Application No: FP/61/26/HH
Site Address: 39 Lindsey Court Felpham Bognor Regis PO22 8JQ
Description of works: Removal of existing detached garage and erection of detached annexe.

Thank you for your internet representation made on 4th June 2026 which has been recorded as an objection with the comments as follows:

Proposed

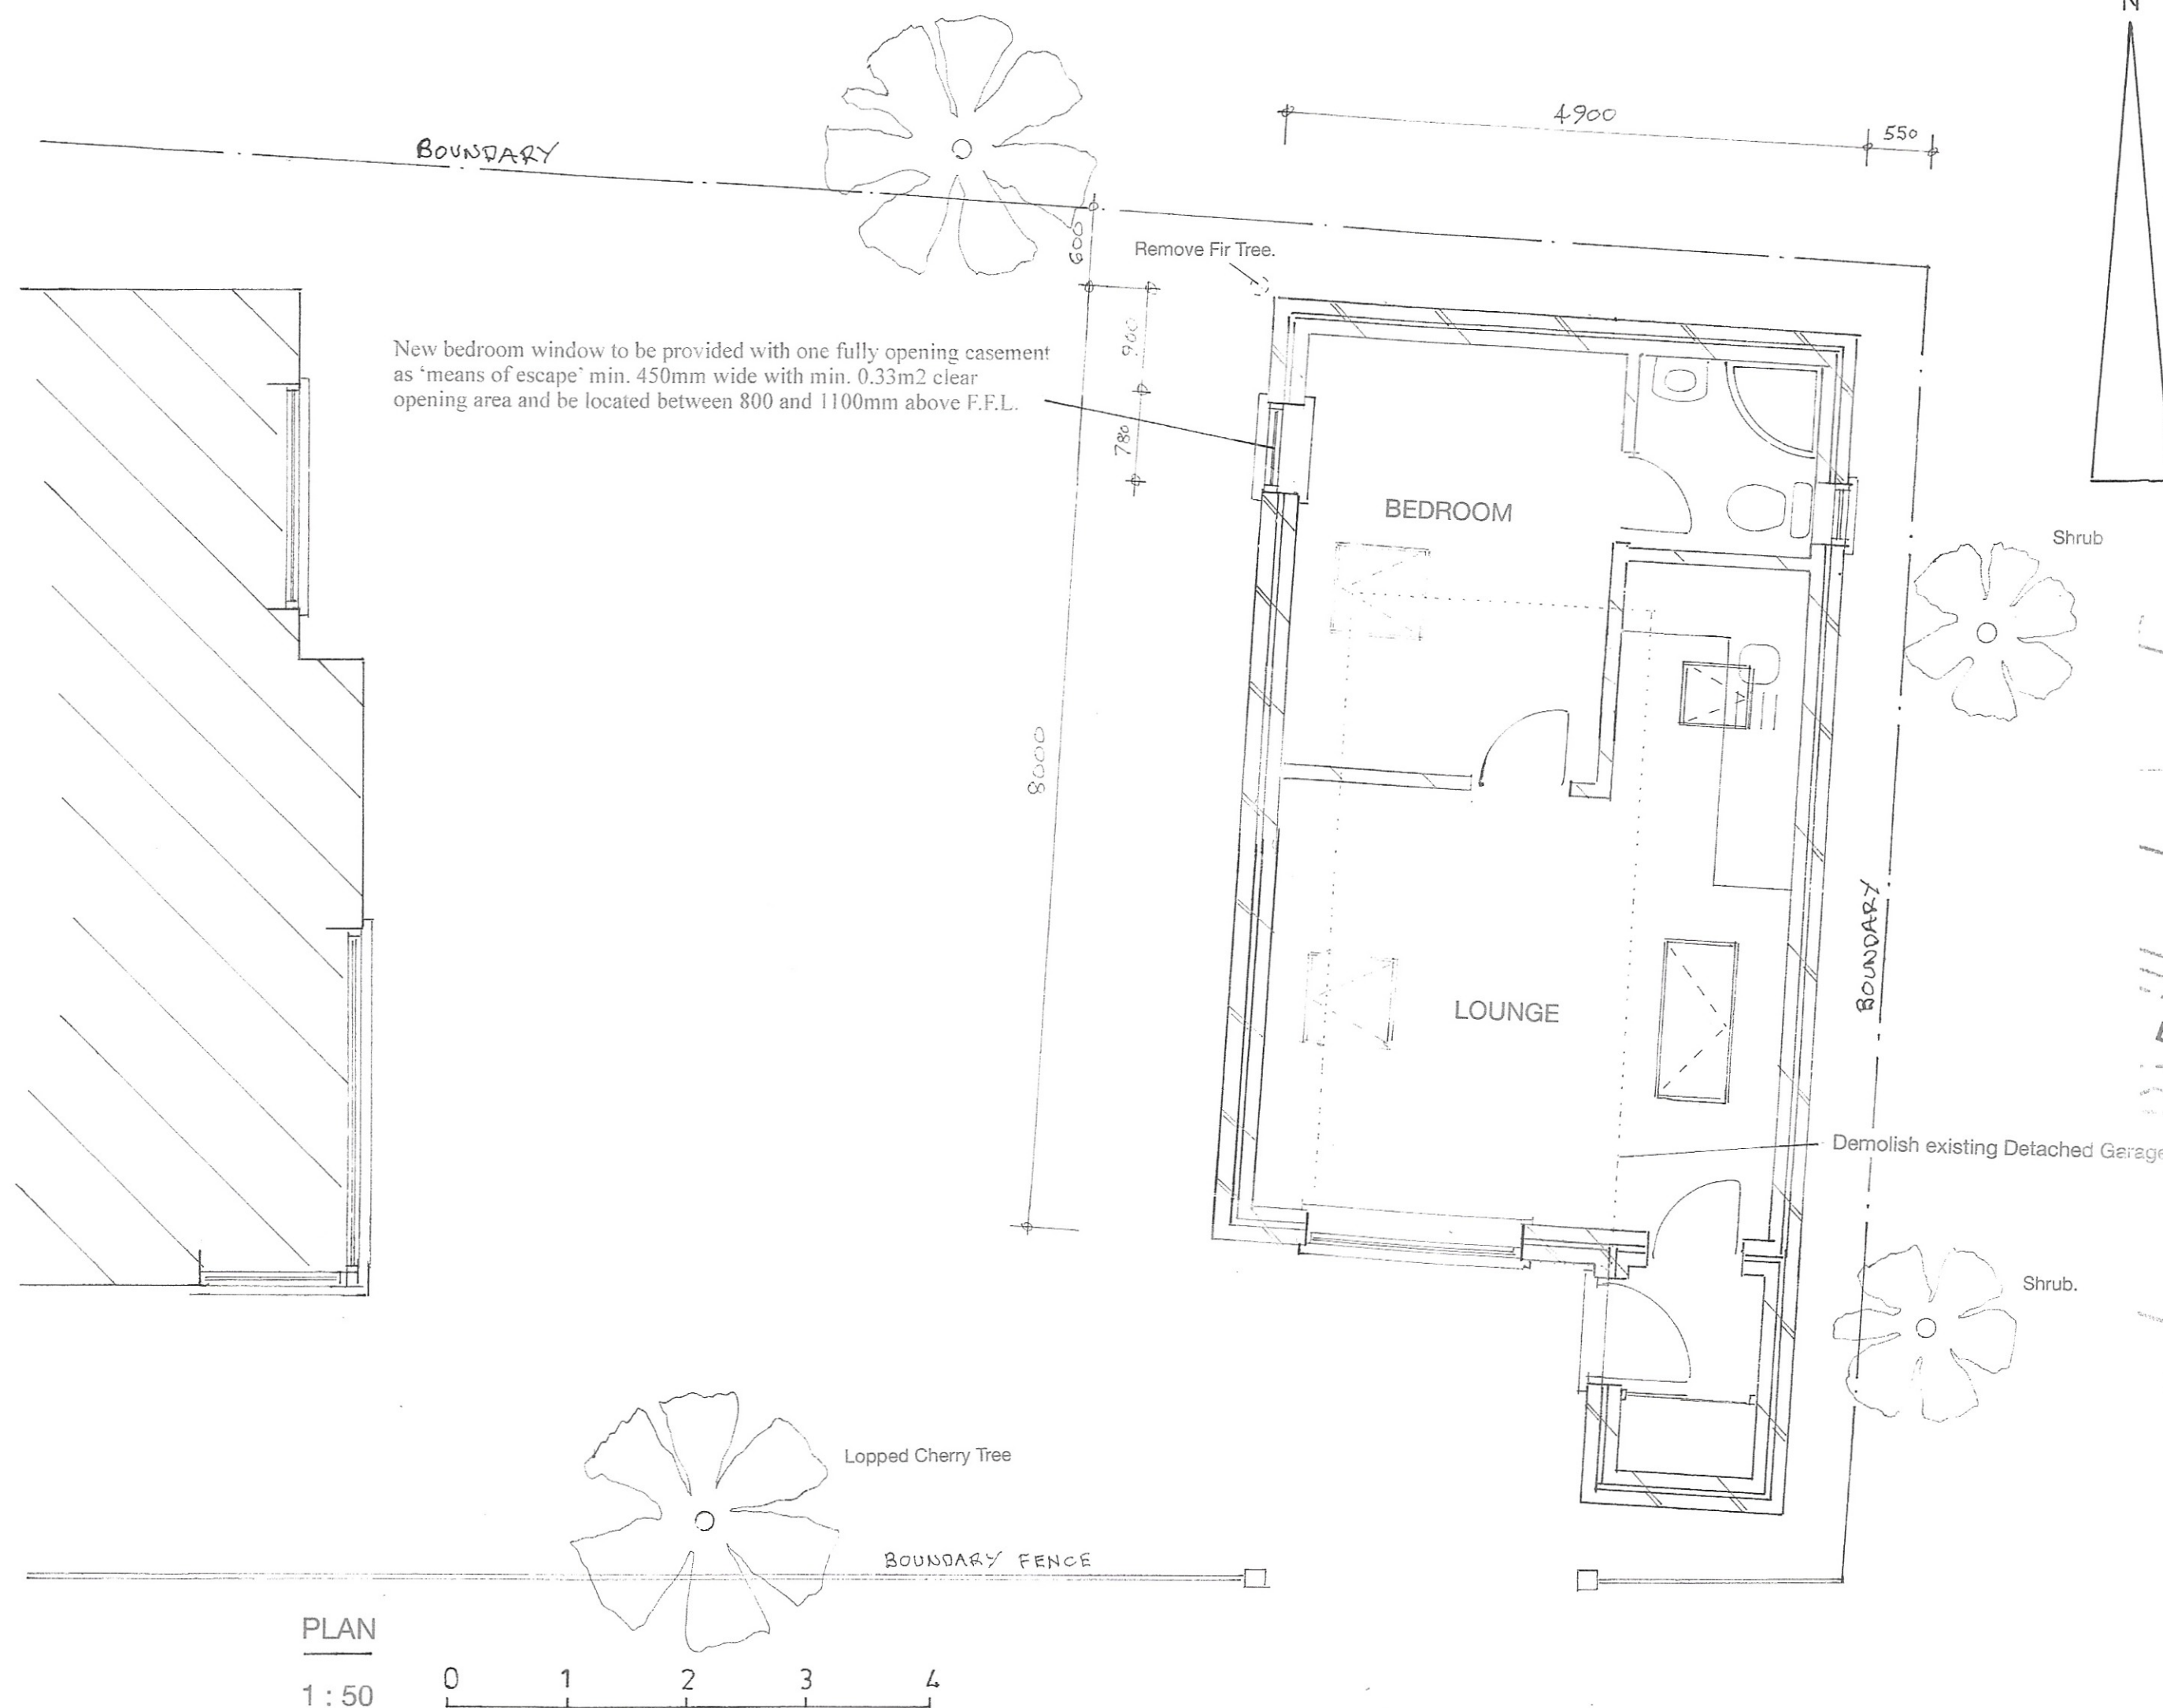
The proposed building would be located directly behind our property and garden and would significantly reduce the natural light currently enjoyed by our home and outdoor space. Unlike the existing garage, which is set back from the boundary with a low flat roof, the proposed structure would be larger, extend further along the boundary, be positioned closer to it, and include a pitched roof. As a result, it would create a more dominant and intrusive presence, adversely affecting our outlook and residential amenity.

Although described as an annexe, the plans include a lounge/kitchen, bedroom, bathroom and separate access. These features would enable independent occupation and suggest the building could function as a self-contained dwelling rather than genuinely ancillary accommodation.

Replacing the garage with a fully serviced residential building represents a significant intensification of development on the plot. The scale and nature of the proposal appear excessive for an annexe and out of keeping with the area's established pattern of single-family dwellings.

Should permission be granted, we ask that conditions be imposed, and last indefinitely, requiring the annexe to remain ancillary to the main dwelling, preventing independent occupation, separate sale, holiday letting or commercial residential use, and ensuring it is located no closer to the shared boundary than the existing garage.
